From: Laura Gibbons <Laura.Gibbons@arun.gov.uk>
Sent: 30 March 2022 14:08
To: Planning.Responses <Planning.Responses@arun.gov.uk>
Cc: Simon Davis <Simon.Davis@arun.gov.uk>
Subject: RE: Planning Consultation on: Y/32/22/DOC

Engineers Comments Regarding Surface Water Drainage

Application No: Y/32/22/DOC

Site Address: 10 Acre Field Grevatts Lane West Yapton Bognor

Project No.	Originator	Volume	Lvl/Loc	Type	Role	Number	Rev
13591	CRH	XX	XX	DR	C	5250	P1

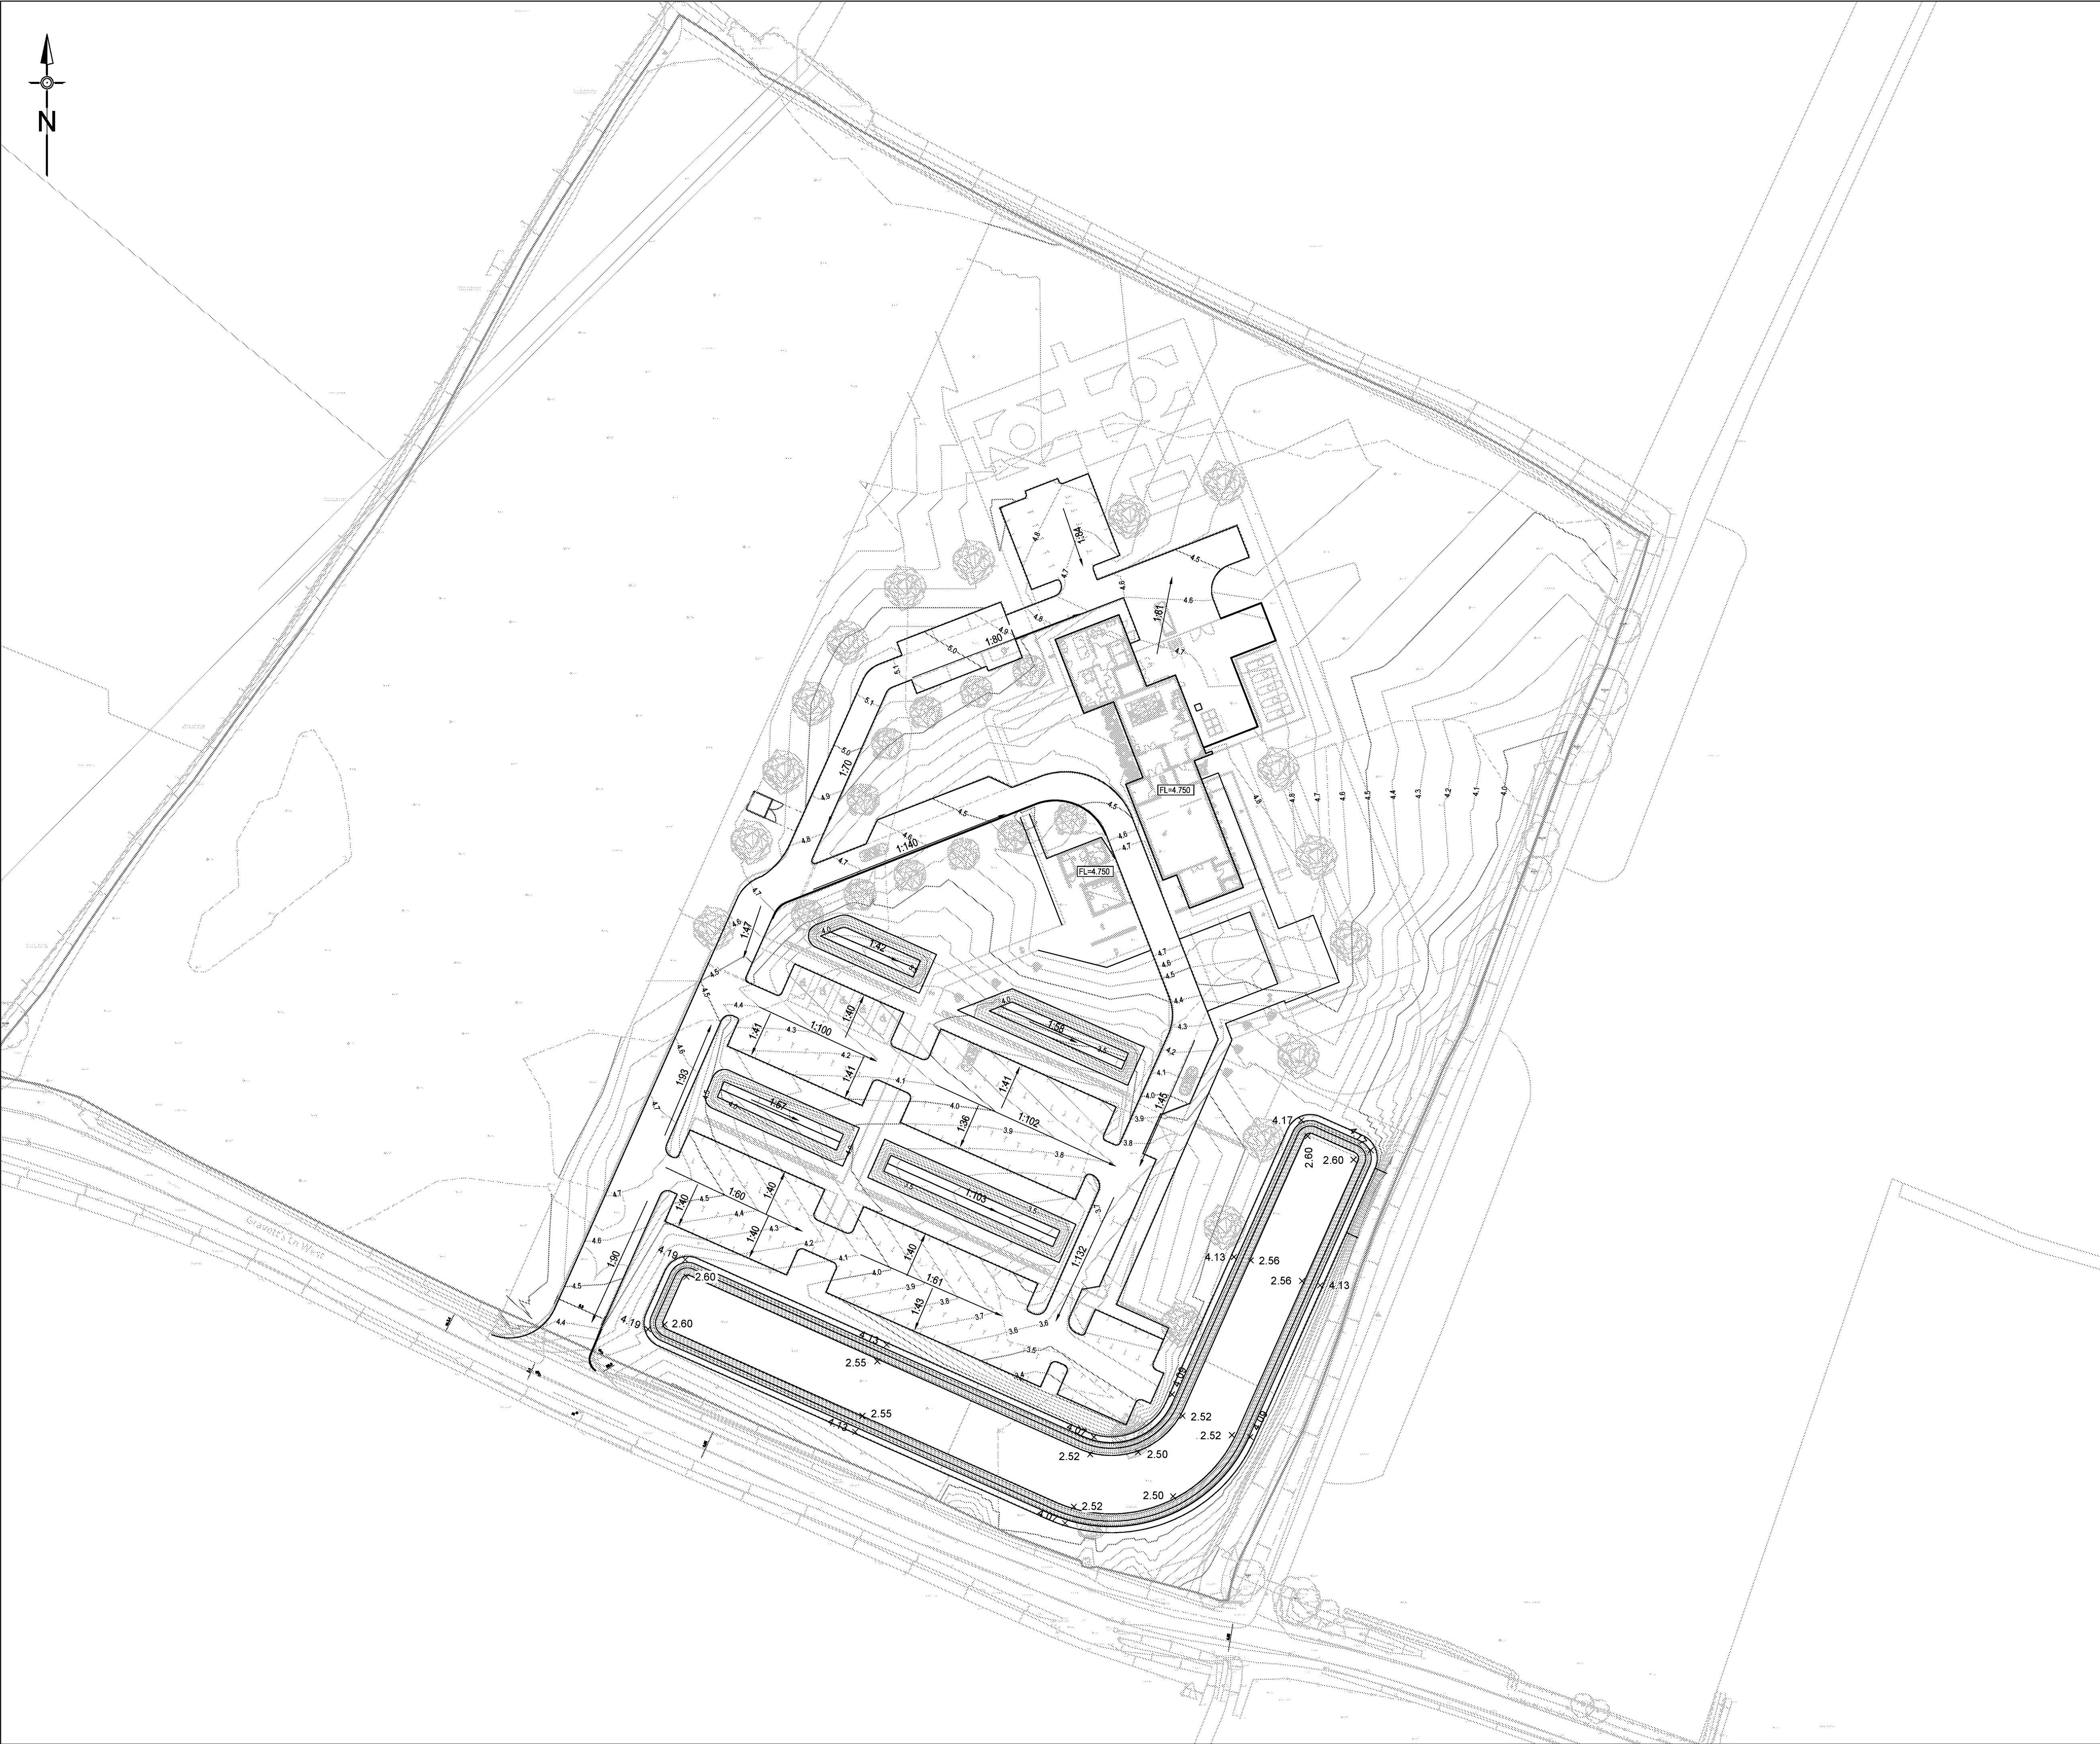
3. **Please supply an impermeable area catchment plan.** Please see enclosed impermeable area plan 13591-CRH-XX-XX-DR-C-5250 Revision P1. Okay.
4. **Please label all pipes with diameter and fall.** Additional pipe labels have been added to drainage layout plans 13591-CRH-XX-XX-DR-C-5050 Revision P6 and 5051 Revision P5. Gradients for short (<5m) pipe lengths have not been shown. Pipe sizes, maximum grades and materials are to be as specified on drainage notes drawing 13591-CRH-XX-XX-DR-C-5300 Revision P1 previously provided. Okay.
